Our ref: SSD-65924461

22 April 2025

Subject: Stephen Road Multi-level Warehouse, Banksmeadow - Additional Matters for Submissions Report

Department's Request for Information

1 NORTH 1:450

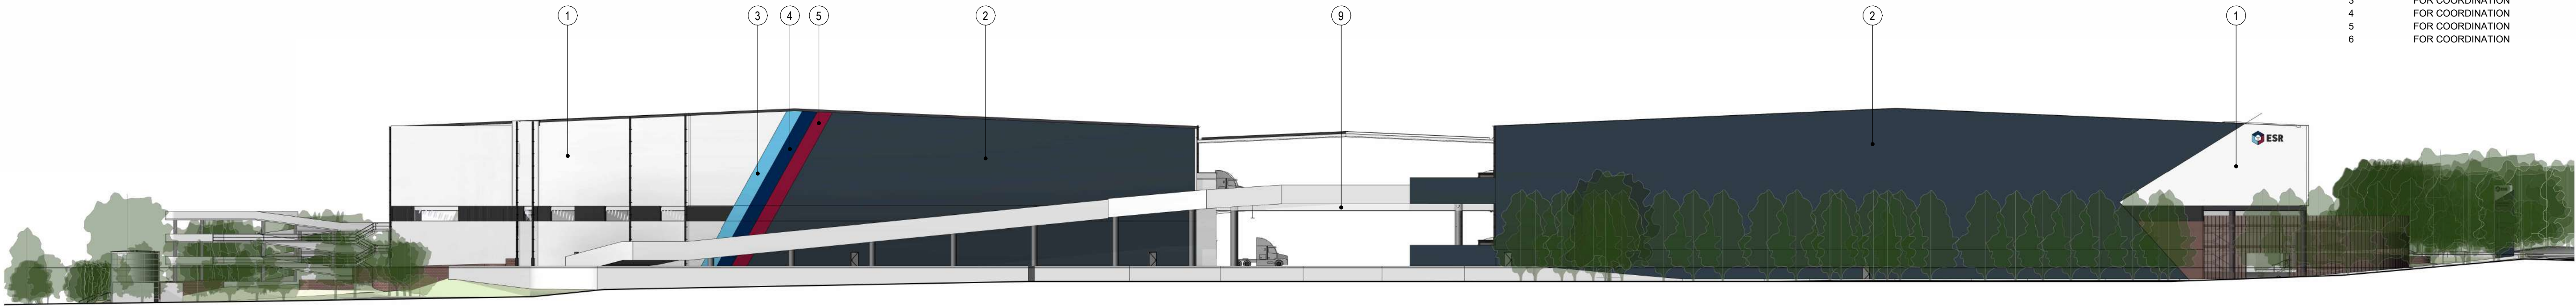
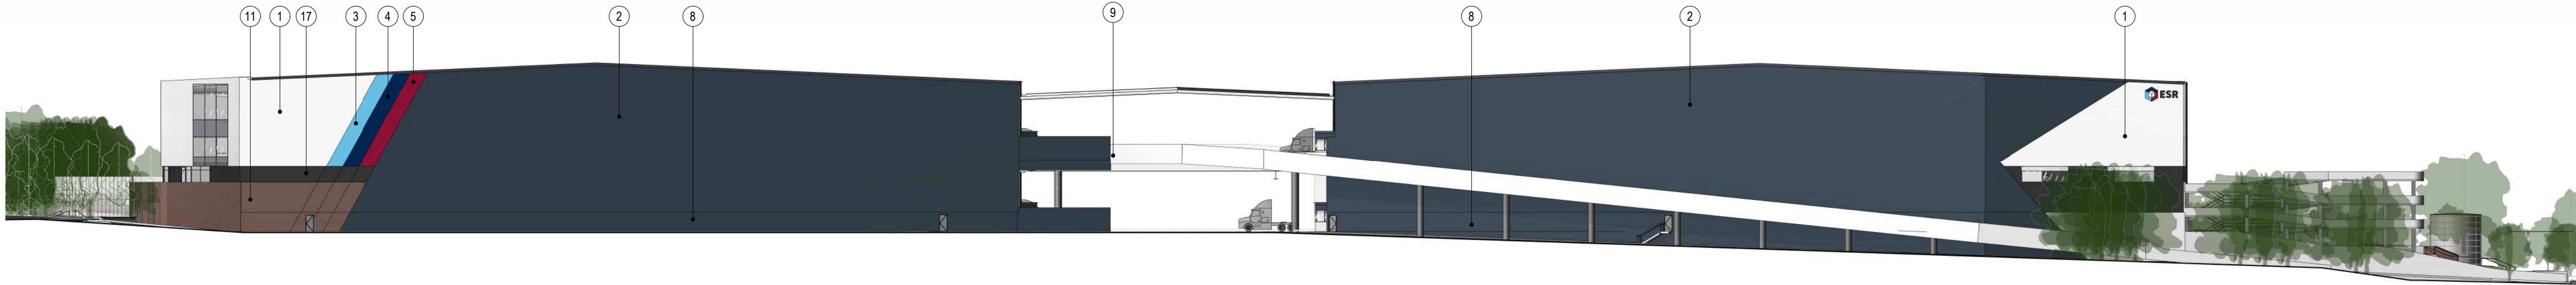
2. The Department has significant concerns regarding the bulk and scale of the proposed development, particularly its visual impact when viewed from the sensitive low-density residential area located directly opposite the site on Stephen Road. The building presents as a monolithic six storey building form to Stephen Road, with a scale and visual dominance significantly exceeding that of surrounding developments, resulting in an incongruous streetscape interface. While the Department acknowledges the industrial character of the eastern side of Stephen Road, the expectation is this interface is to act as a transition area between residential uses and the Stephen Road industrial area, meaning the design requirements/aesthetics are more onerous.

As such, the Department requests that the design of the building fronting Stephen Road be revised to ensure a more contextually appropriate and visually compatible outcome. This should include, but not be limited to, significantly increasing the upper-level setbacks to reduce the perceived bulk and scale of the warehouse particularly when viewed from the residential interface.

3. The visual dominance of the building is further exacerbated through the use of large blank facades to Stephen Road, including the building's ground level interface which is largely unarticulated and dominated by vehicle ramps. This must also be revisited as part of the above design changes.

5. The eastern façade of the building presents as a 'back of house' elevation, despite being clearly visible from Coal Pier Road. This includes unsightly views of the underside and structural supports of the three storey spiral heavy vehicle ramps. Given the building's considerable size, the eastern elevation must be reviewed to provide a more 'front' facing façade due to its exposure to the public domain.

1 STREET SECTION 1 1 : 200

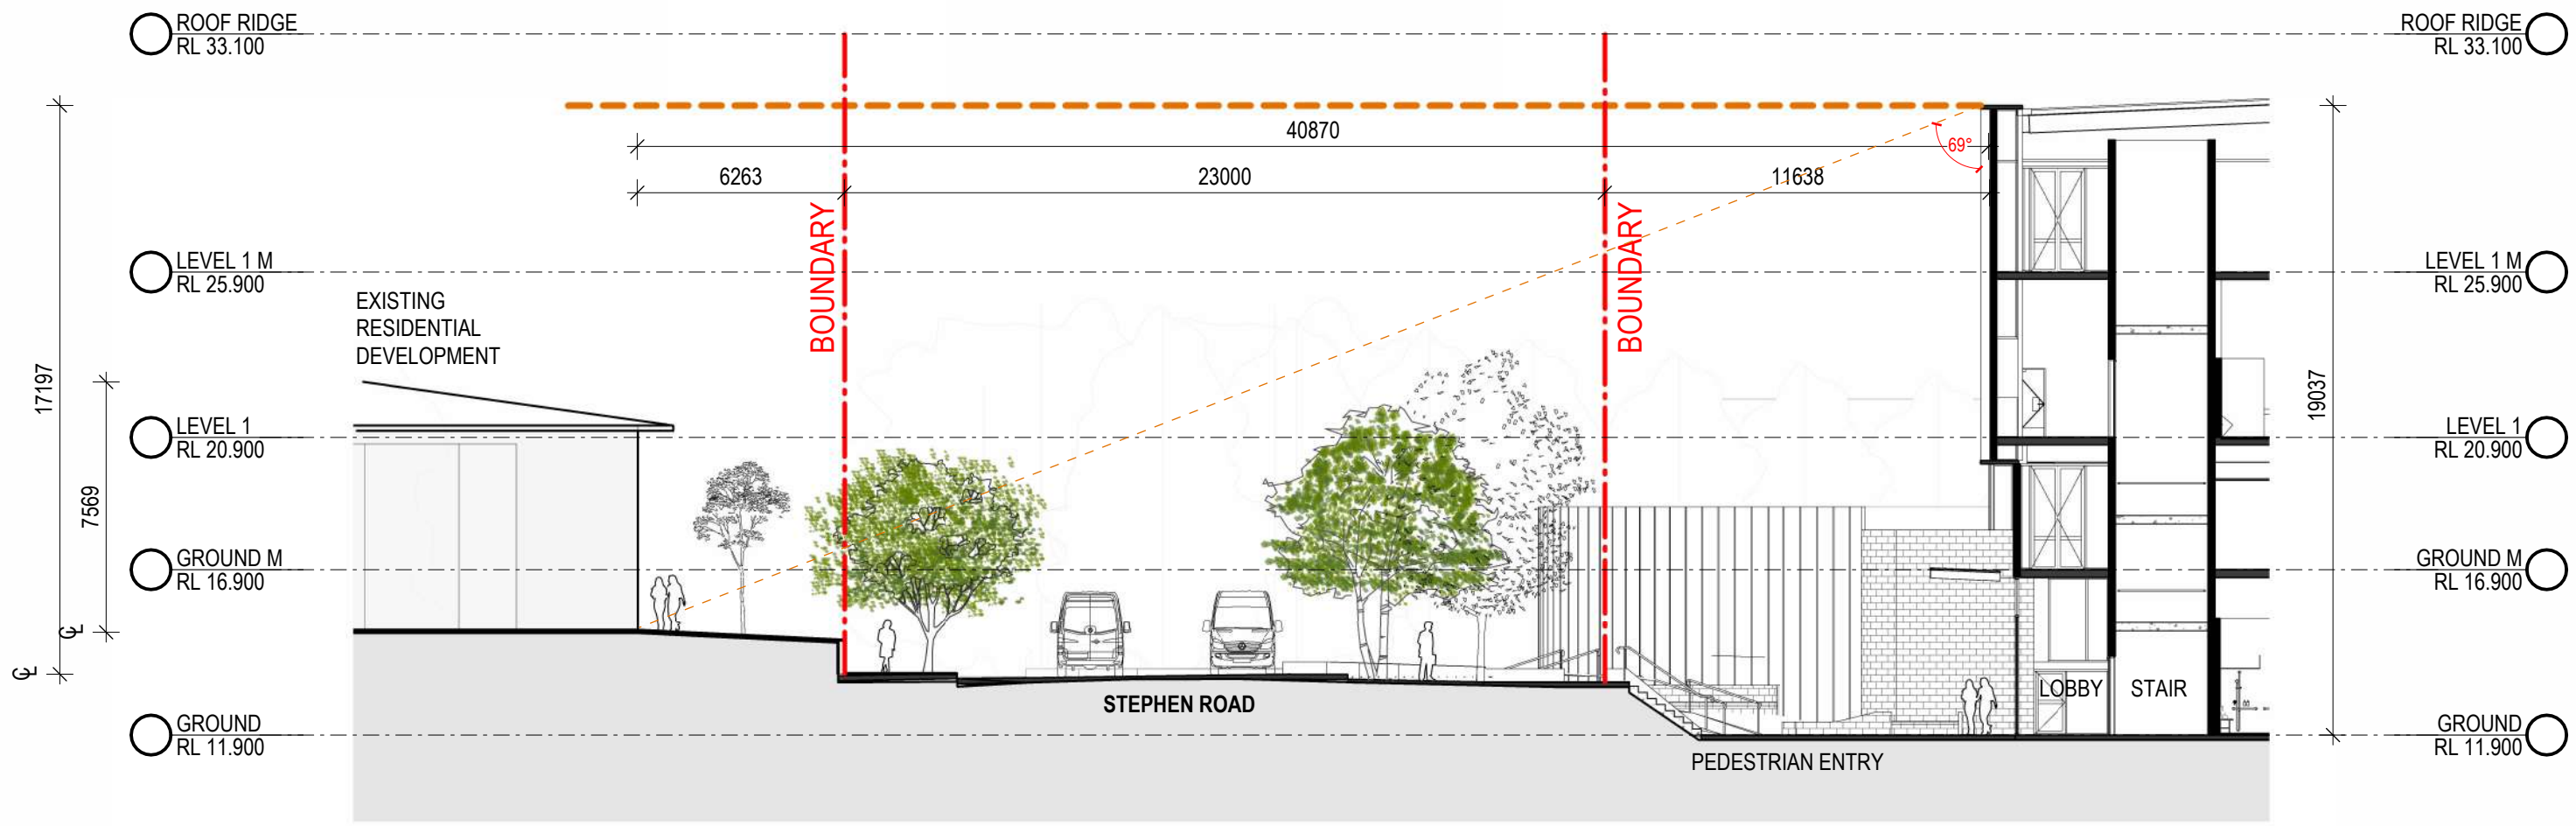
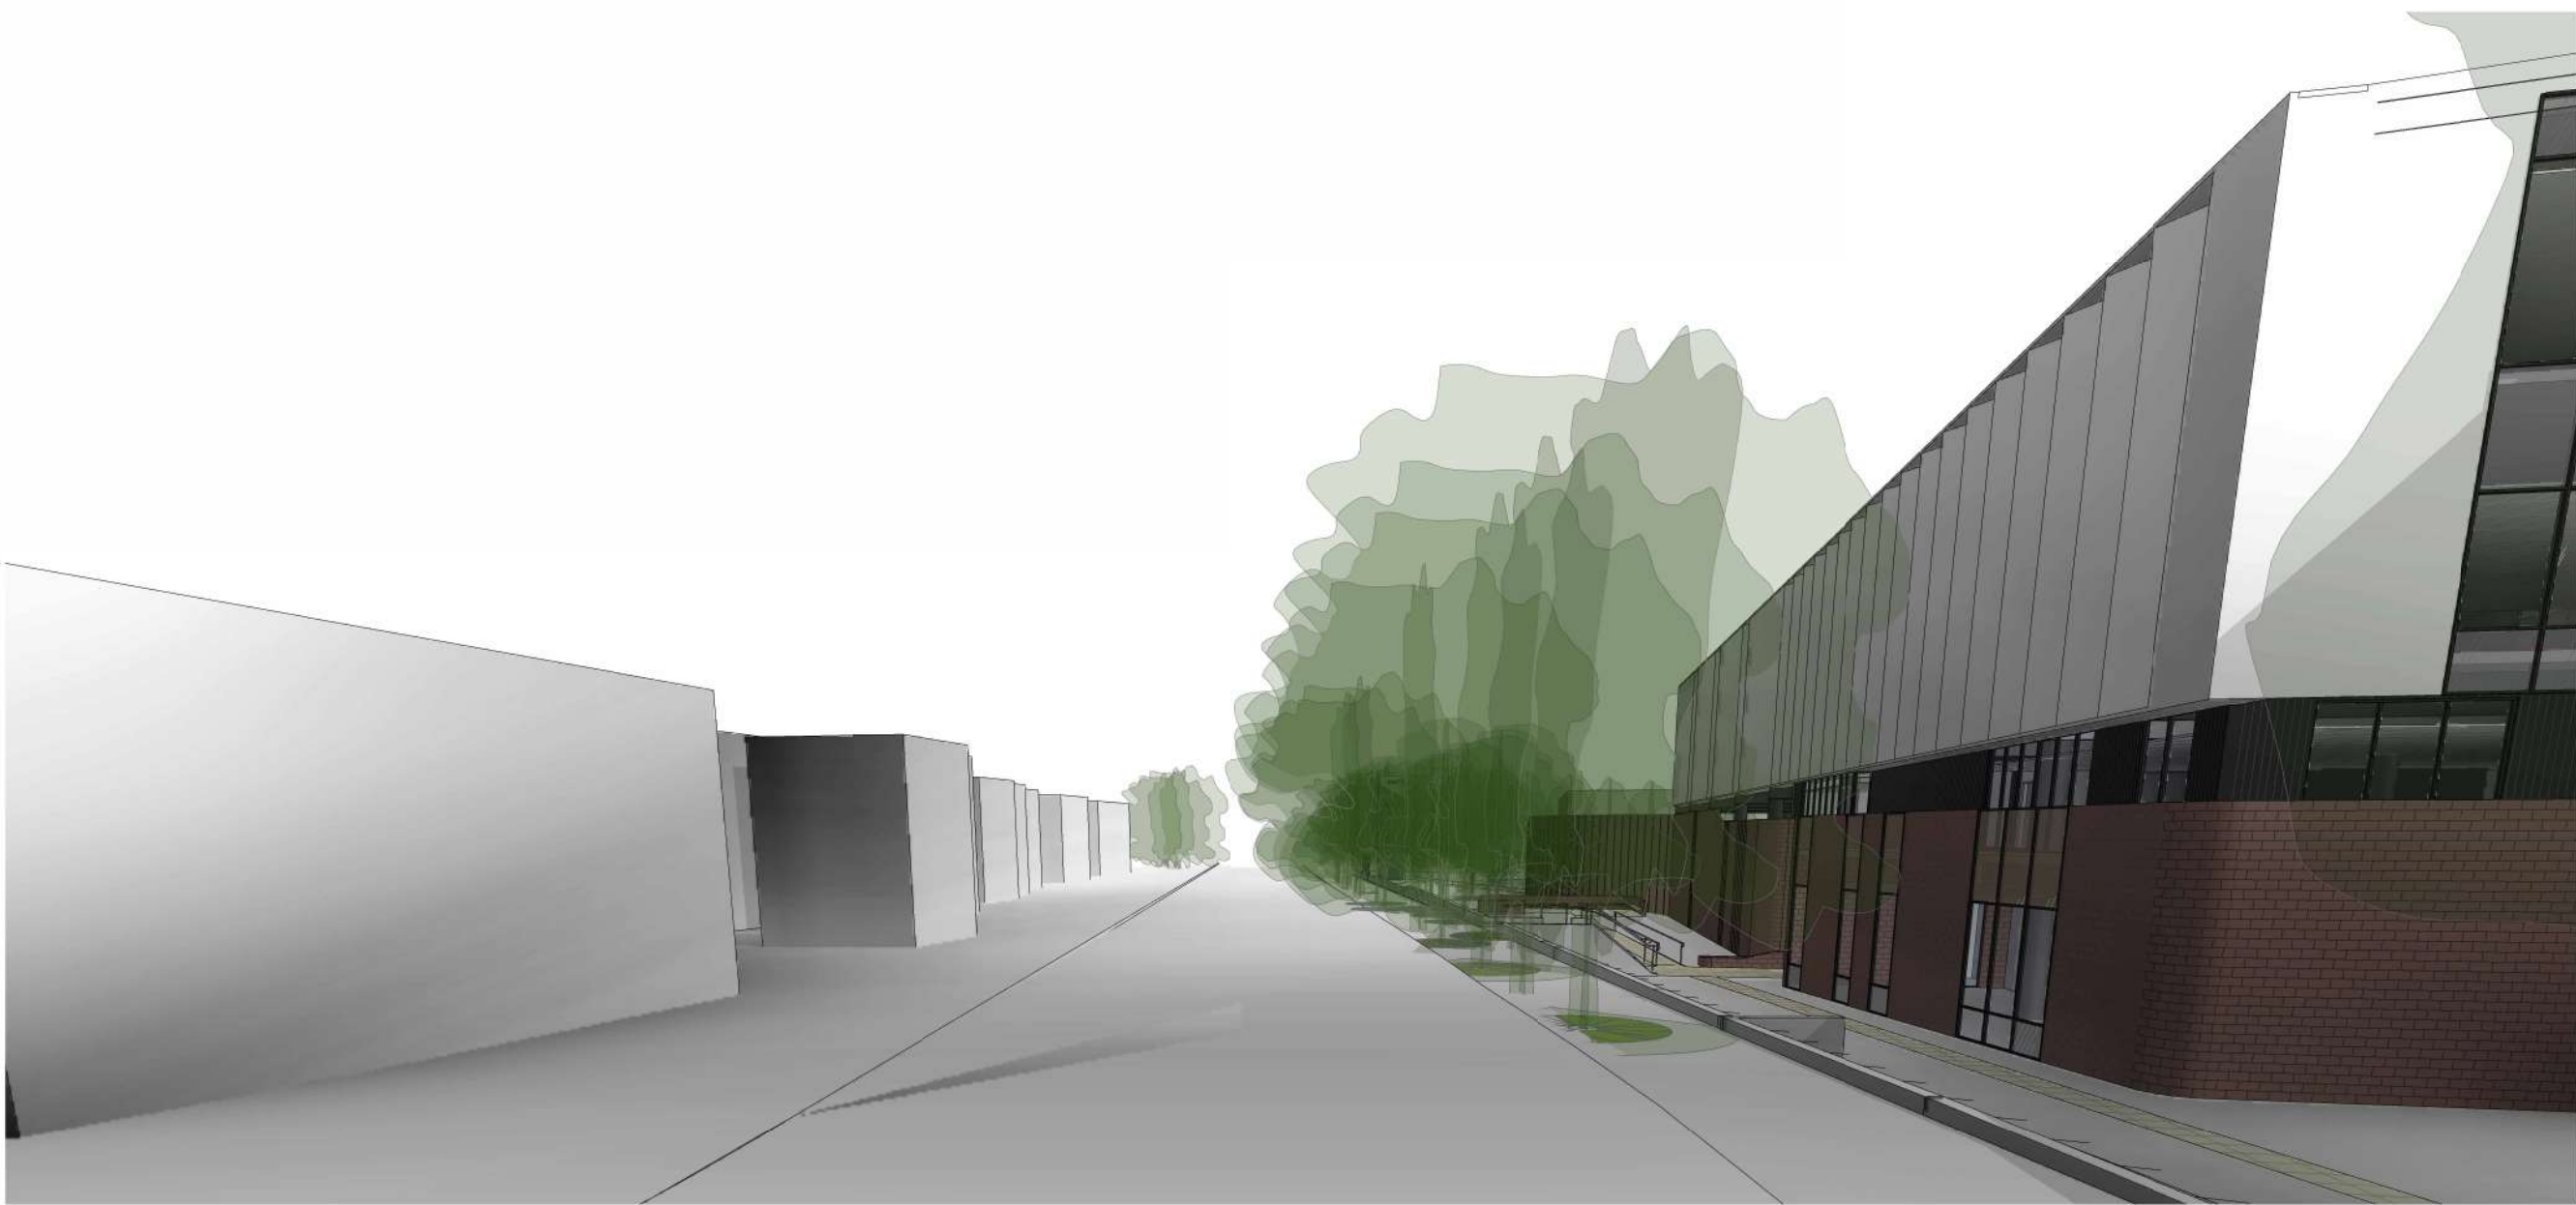
6. The proposal includes fencing along the Stephen Road site boundary, creating a further hard barrier to Stephen Road. The Department recommends setting the fencing further back behind landscaping, or removing it entirely where not operationally required, to allow for the
